# TOGA Central, Henry Deane Plaza, Sydney Landscape RTS Submission

Prepared for TOGA  
December 2022

Response to submission

Provide a revised public domain package that provides a comprehensive and integrated design to the CPS site at interim and final stages of the development of the site including:

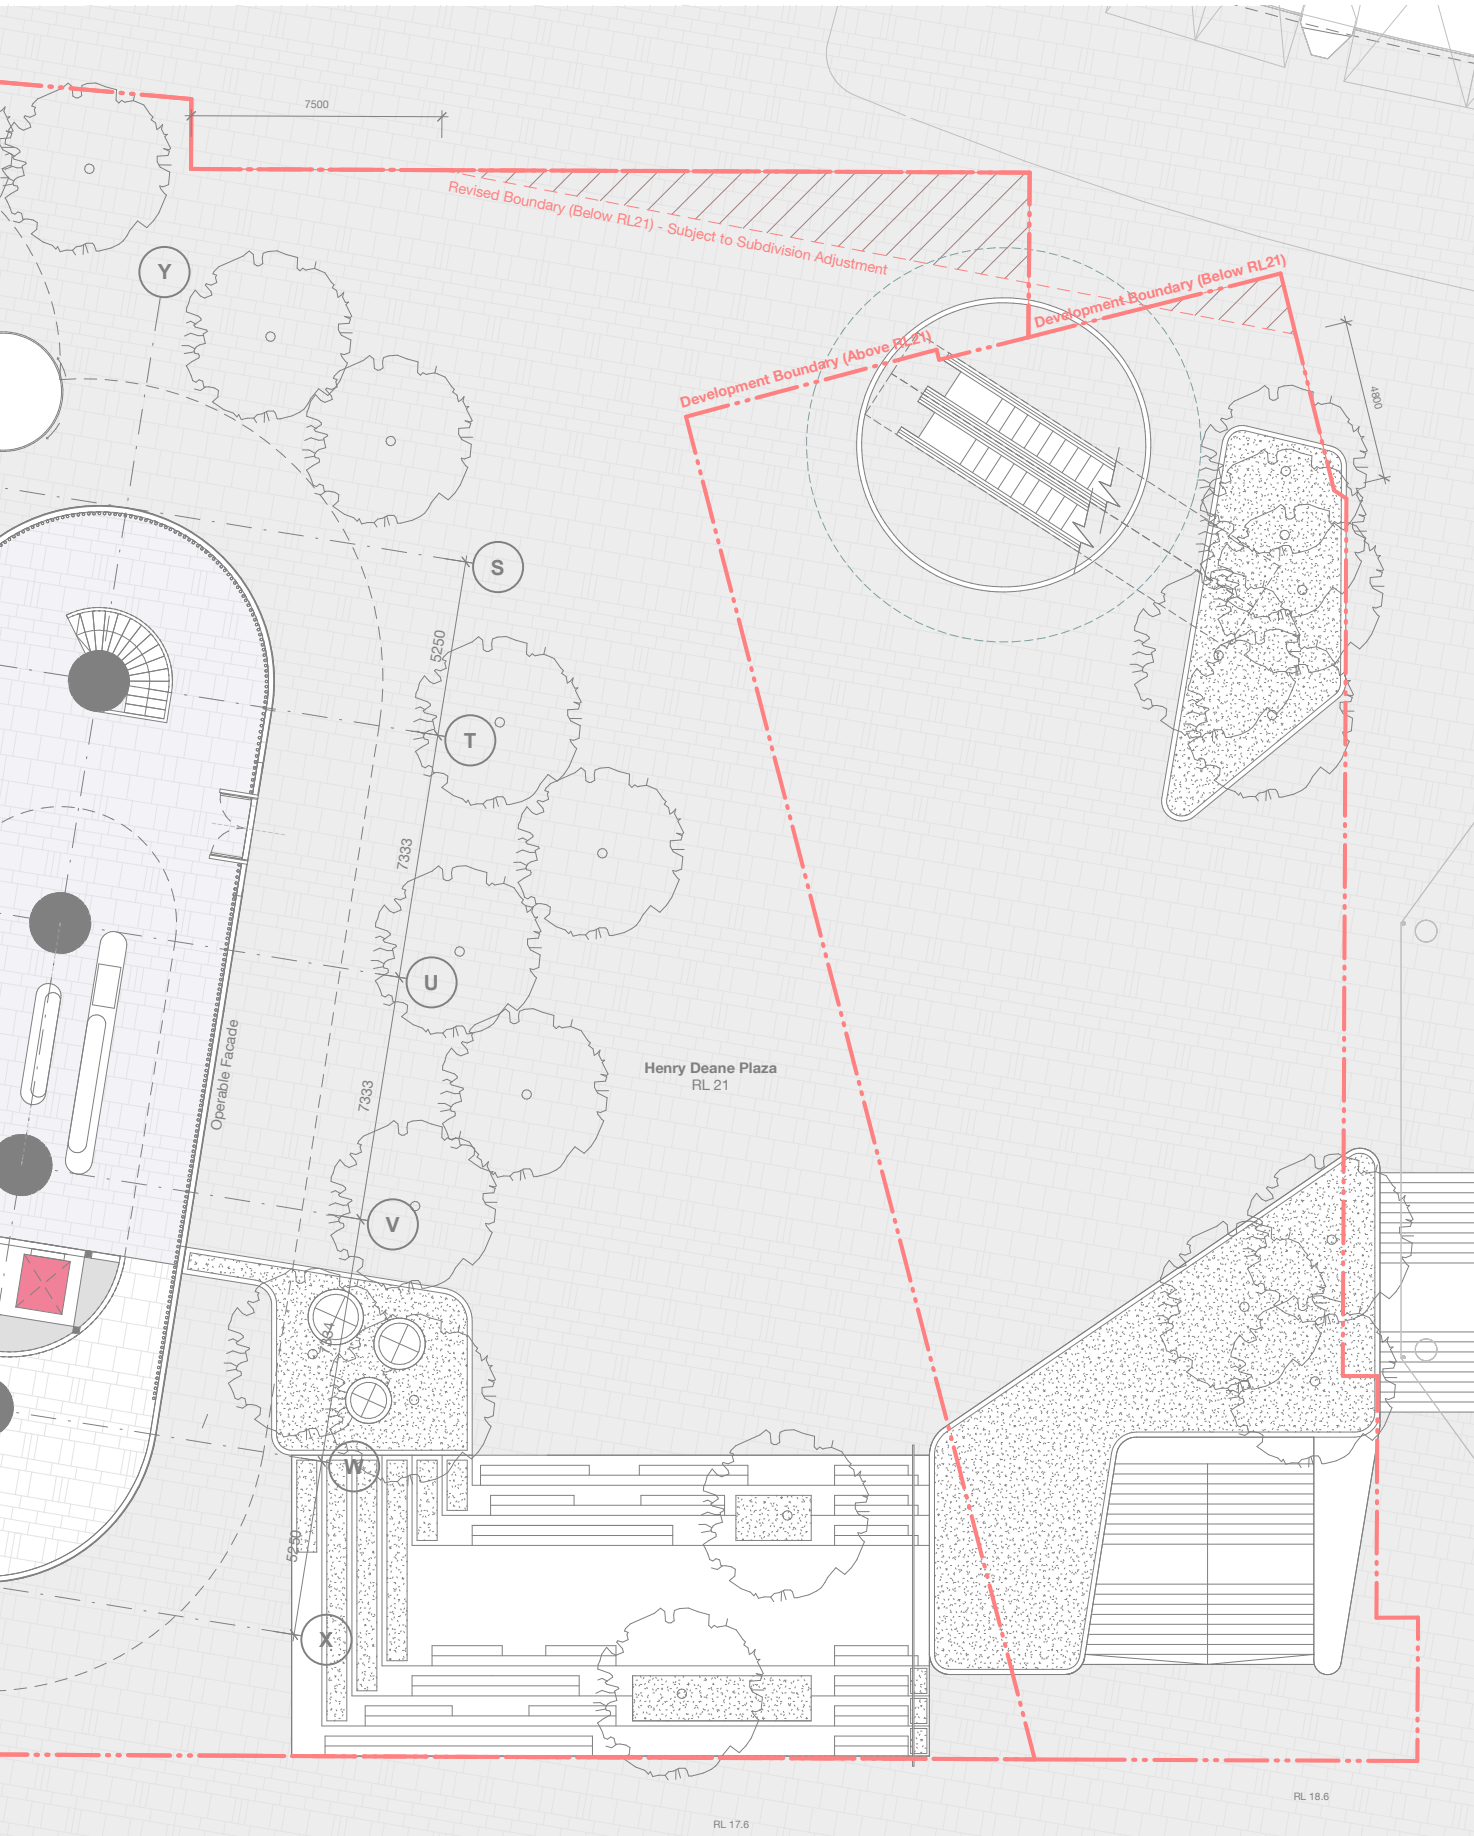
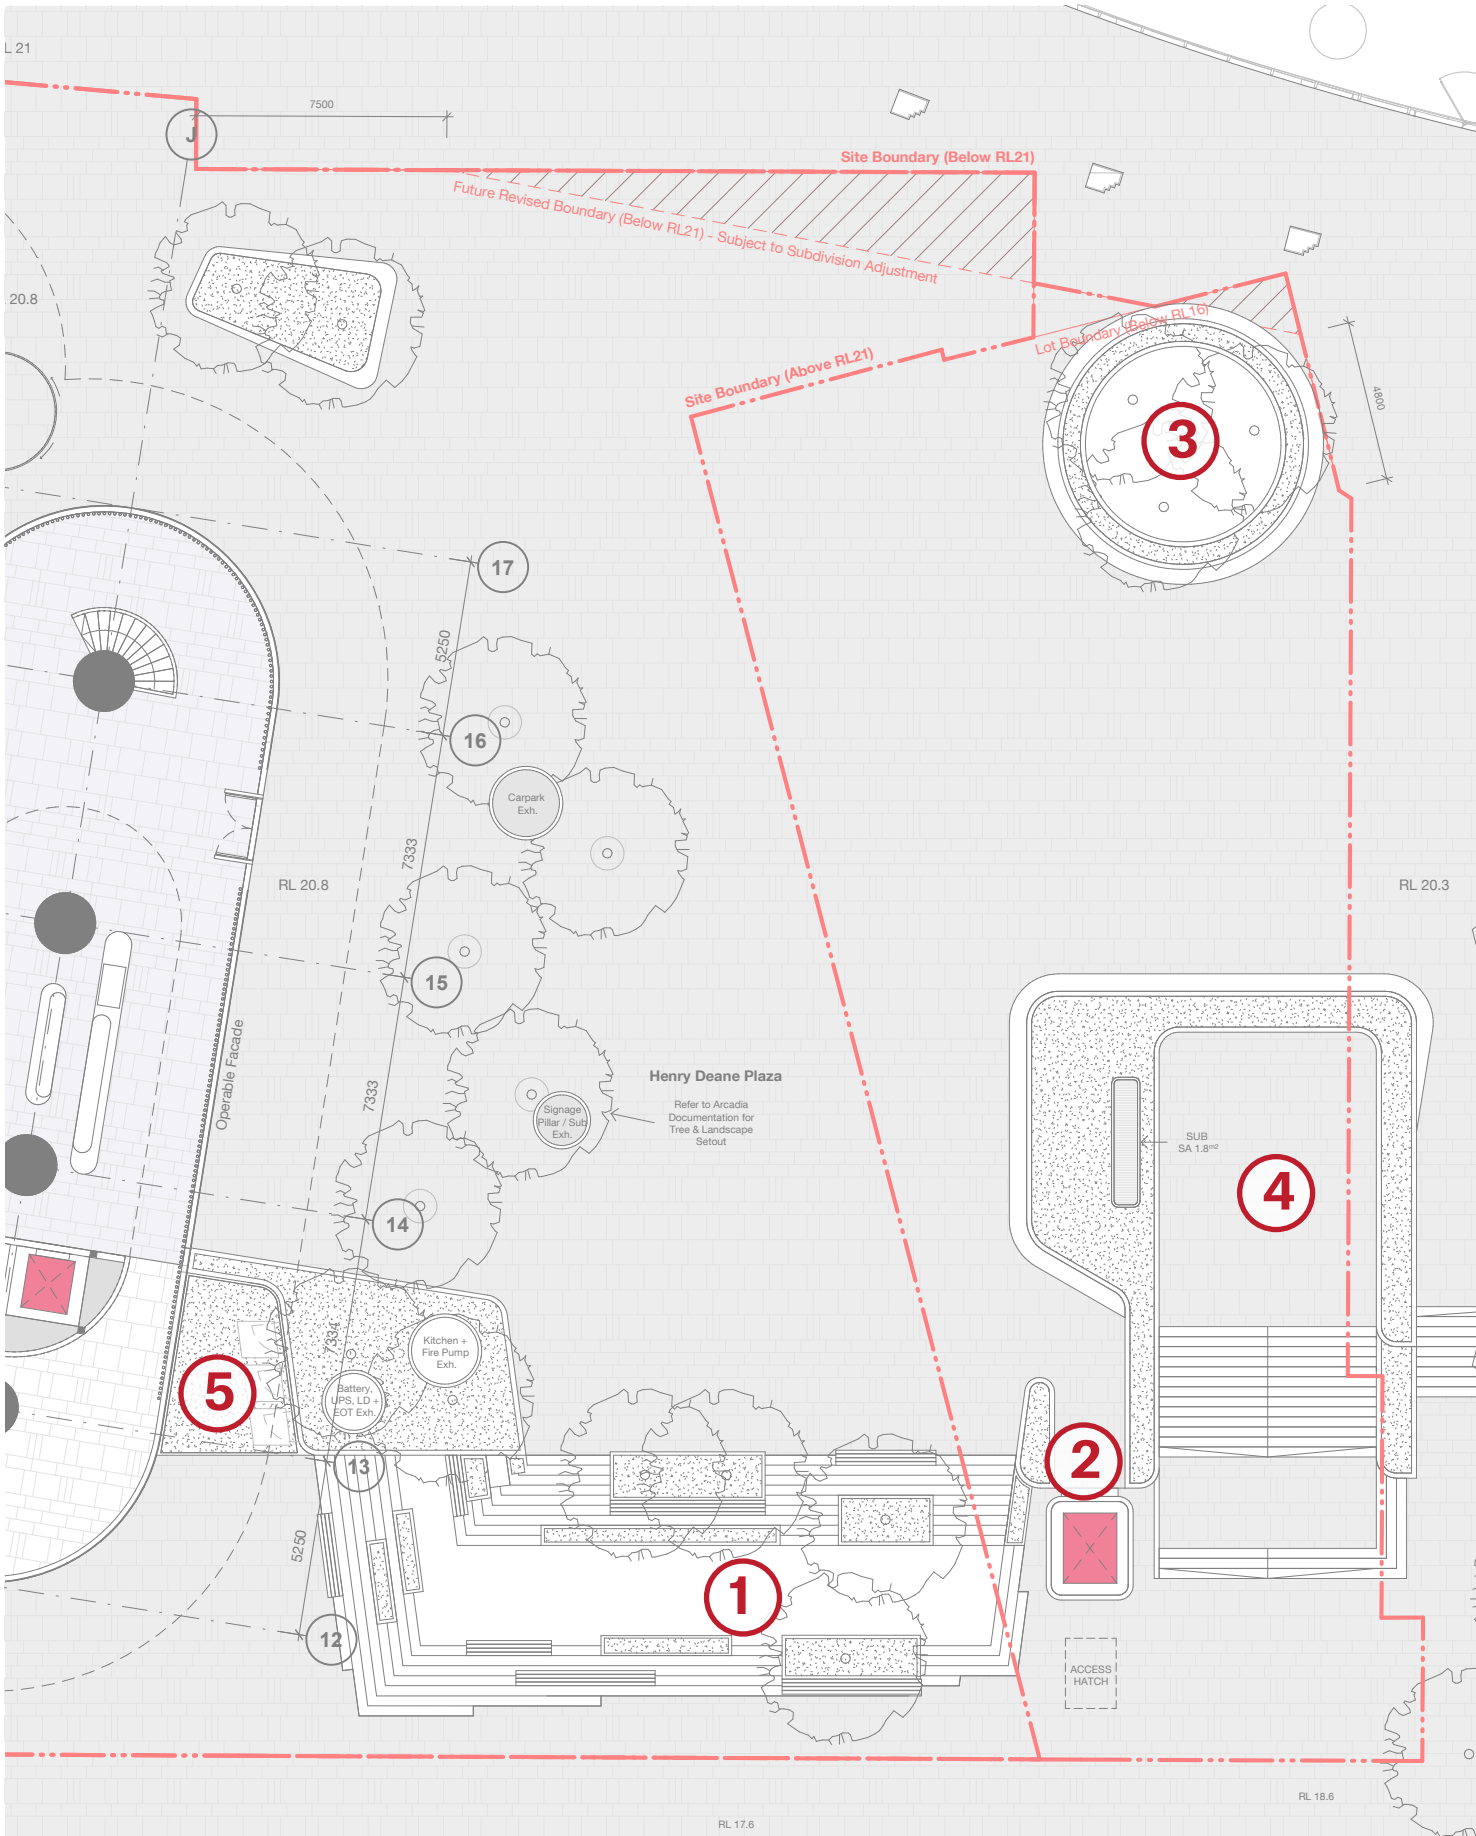
Item	Description of Requirement	Response
1	<p>Public Domain and Landscaping</p> <p>12. Provide a revised public domain package that provides a comprehensive and integrated design to the CPS site at interim and final stages of the development of the site including:</p> <p>a) integrated levels between the design of the upper ground floor public domain treatment within the site and adjoining proposed CPS development</p> <p>b) equitable access from Lee Street to the upper and lower ground floor levels</p> <p>c) details of materials and finishes that create a consistent design throughout Henry Deane Plaza.</p> <p>d) resolution of the proposed dead spaces located between the Henry Deane Plaza stairs fronting Lee Street and the glazed tower atrium and between the eastern and southern ‘pill’ buildings (Figure 2).</p>	<p>Weekly Coordination meeting have occurred between TOGA Central and CPS teams between October to November to ensure that a coordinated design between the sites is achieved and a cohesive Henry Deane plaza public domain design has been achieved including levels, paving, materials and urban elements which have in principle been agreed to by the adjoining owners.</p>

<ul style="list-style-type: none"><li>• 2.2 Coordination of Henry Deane Plaza</li><li>•</li><li>• The EIS acknowledges Henry Deane Plaza as the ‘missing piece’ that will complete the composition between the Atlassian, Central Place Sydney and Toga Central developments within the existing Central Station precinct.</li><li>•</li><li>• However, there is a lack of coordination and consistency between the Landscape Plans submitted for Toga Central and those submitted for the Central Place Sydney DA (D/2021/251) which is currently under assessment by the City, despite both sets of Landscape Plans being prepared by the same Landscape Architect.</li><li>•</li><li>• The Landscape Plans accompanying the EIS are conceptual and incomplete, and the levels do not match those shown on the Landscape Plans for Central Place Sydney.</li><li>•</li><li>• It is essential that the design of Henry Deane Plaza is fully coordinated between the Toga and Dexu Frasers proposals.</li><li>•</li><li>• Recommendations:<ul style="list-style-type: none"><li>• The Landscape Plans for Henry Deane Plaza must be updated so that the design and detailing are consistent with the Central Place Sydney Landscape Plans. As submitted, these plans vary significantly. The Landscape Plans submitted with the SSD are conceptual, incomplete and have insufficient detail to properly assess the proposed landscaping and public domain works at lower and upper ground levels.</li><li>•</li><li>• The levels on the Toga Central Landscape Plans and those shown on the Central Place Sydney Landscape Plans do not match. The plans must be updated to ensure the correct levels are shown across the development.</li><li>•</li><li>• The Architectural and Landscape Plans for Toga Central must clearly indicate the design and detail for the Day 2 stage of Henry Deane Plaza.</li></ul></li></ul>	<p>Since the submissions of both Toga’s SSDA and CPS’s revised DA, Toga and CPS have engaged in regular design coordination meetings to achieve further alignment design for Henry Deane Plaza. The collaboration between Toga and CPS design teams have significantly resolved an approach to the interfaces between the two development sites.</p> <p>This RTS includes a revised public domain design for Henry Deane Plaza that represents the outcome of coordinated and agreed design. Refer to Page 19, 37-45</p>
